RE: Pomeroy Critical Areas Variance
Your Letter Dated April 12, 2000
PCE Job No. POMY-0001

VAR0006-001
VAR0003-002
VAR0003-007

The following summarizes the applicant's responses to your letter referenced above. The numbering scheme used below follows your letter.

WASHINGTON
 CITY OF MERCER ISLAND,
G.C. POMEROY RESIDENCE
 PROPOSED DRIVEWAY PROFILE
 SITE SECTIONS AND

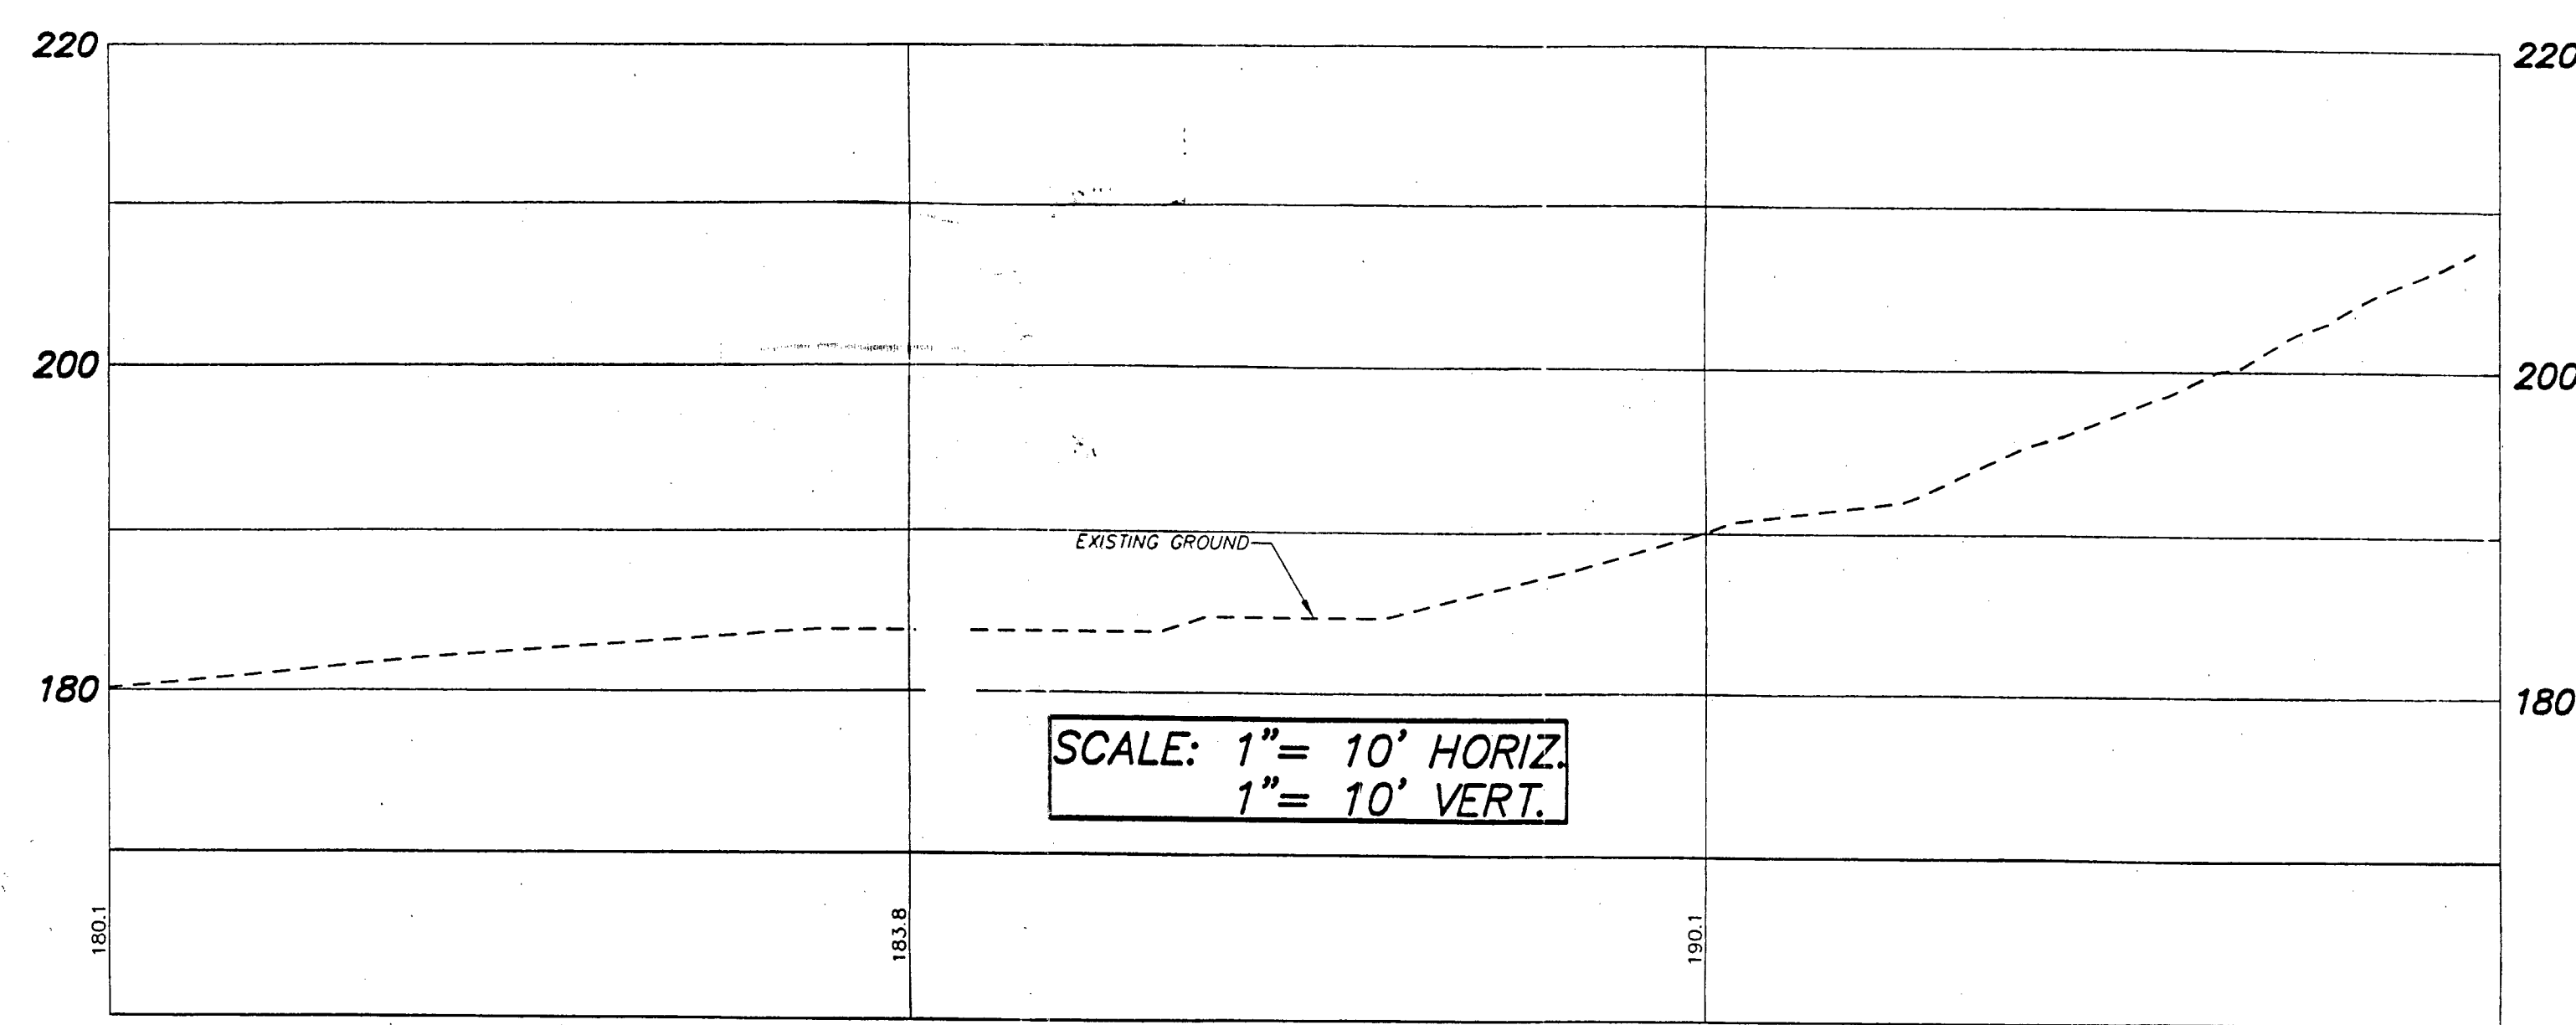
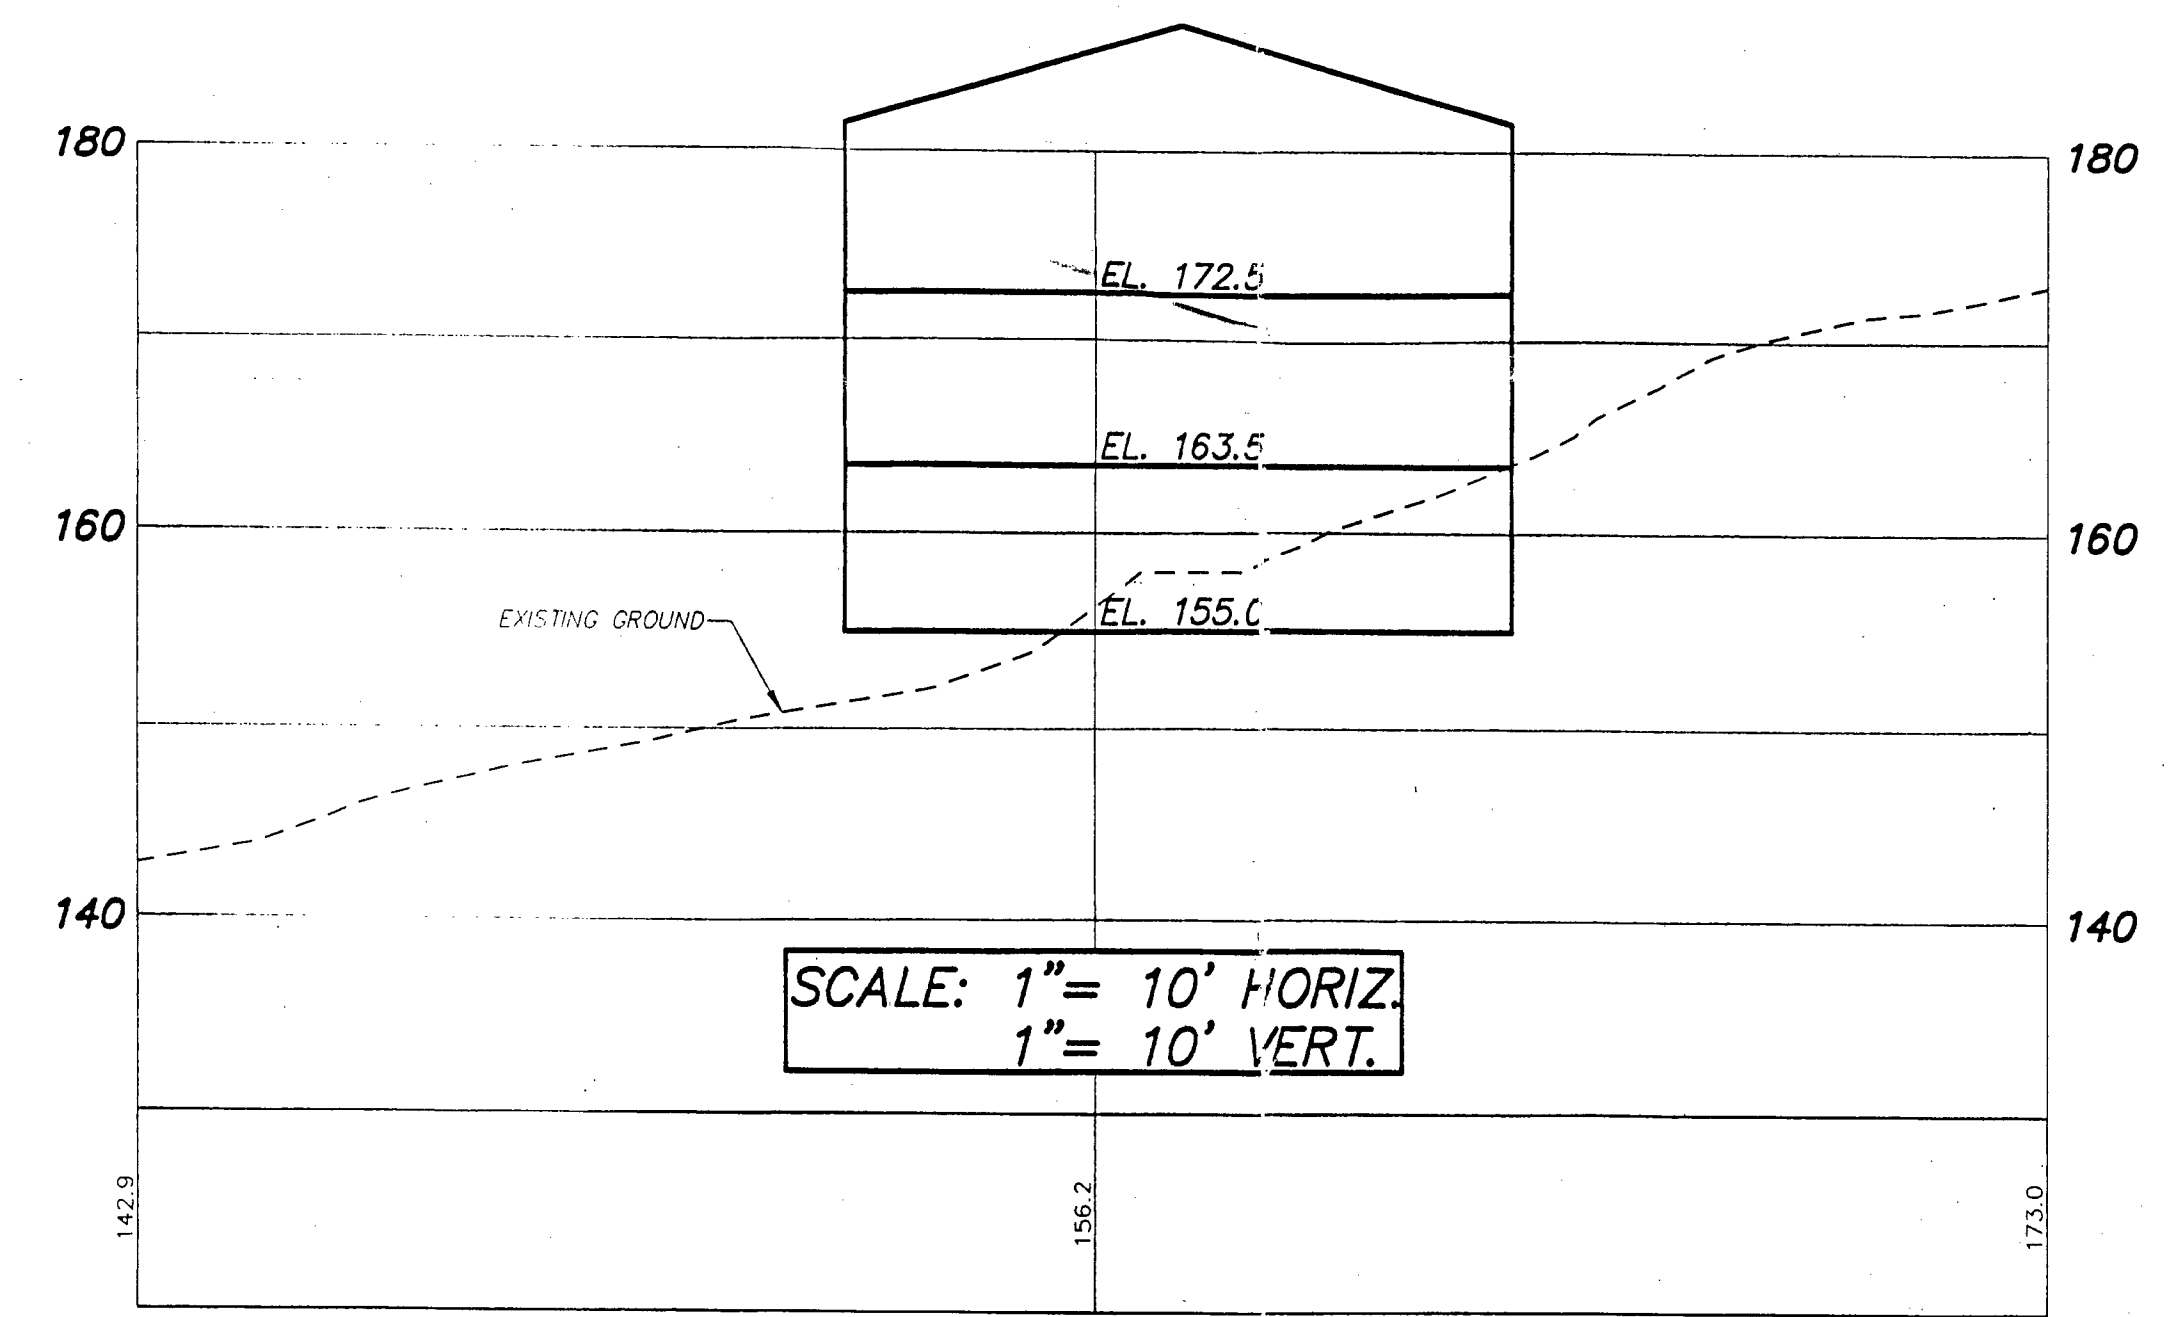
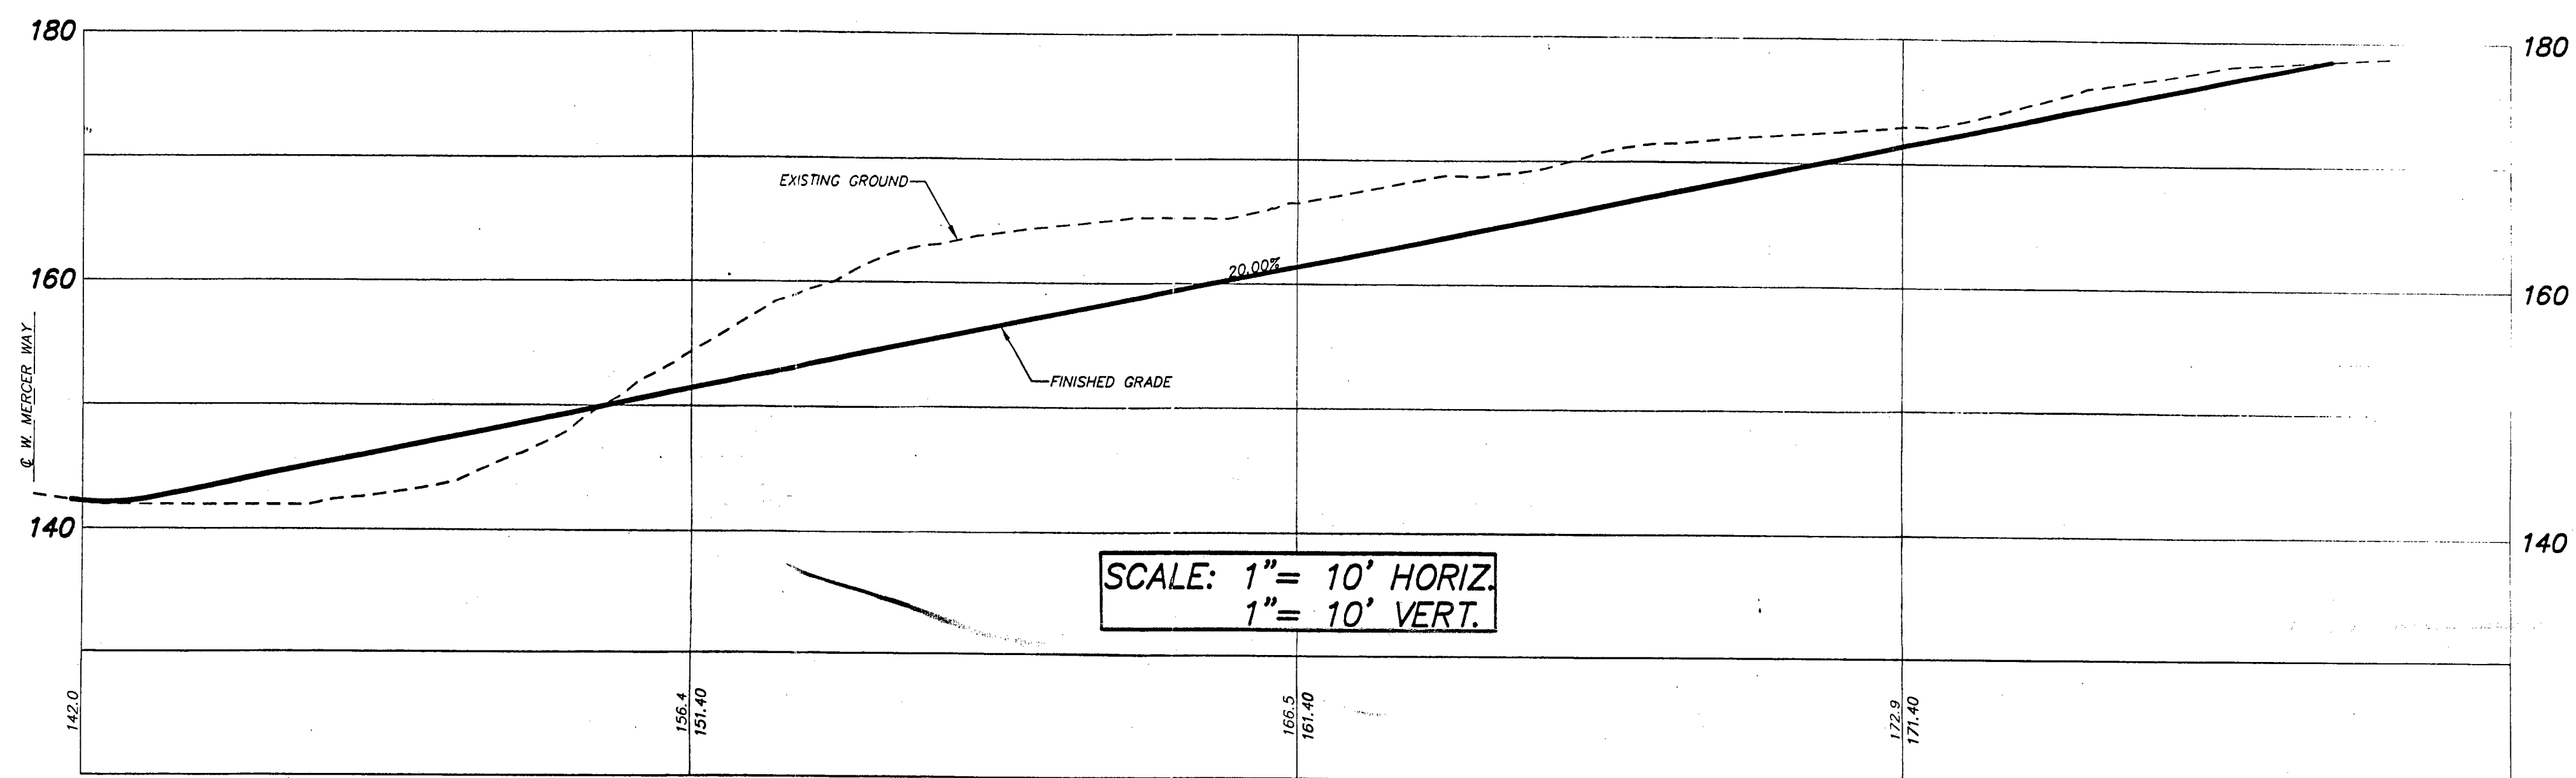
4. Cross sections have been added on sheet 1 of 1 dated June 6, 2000 and enclosed with this submittal.
5. The original roadway alignment was used to minimize disturbance on the lot. We have now re-aligned it slightly to accommodate a passenger vehicle to enter W. Mercer Way at a right angle.

6. The profile has been added to sheet 1 of 1 dated June 6, 2000 and enclosed with this submittal.
7. We estimate approximately 120 cubic yards ("c.y.") of excavation and 230 c.y. of embankment will be required for the access driveway serving the lots. The finished floor elevation and other design details for the home on lot 2 are not yet finalized; however, the building and elevations shown on sheet 3 of 3 and 1 of 1 indicate approximately 180 c.y. of excavation and 140 c.y. of embankment.
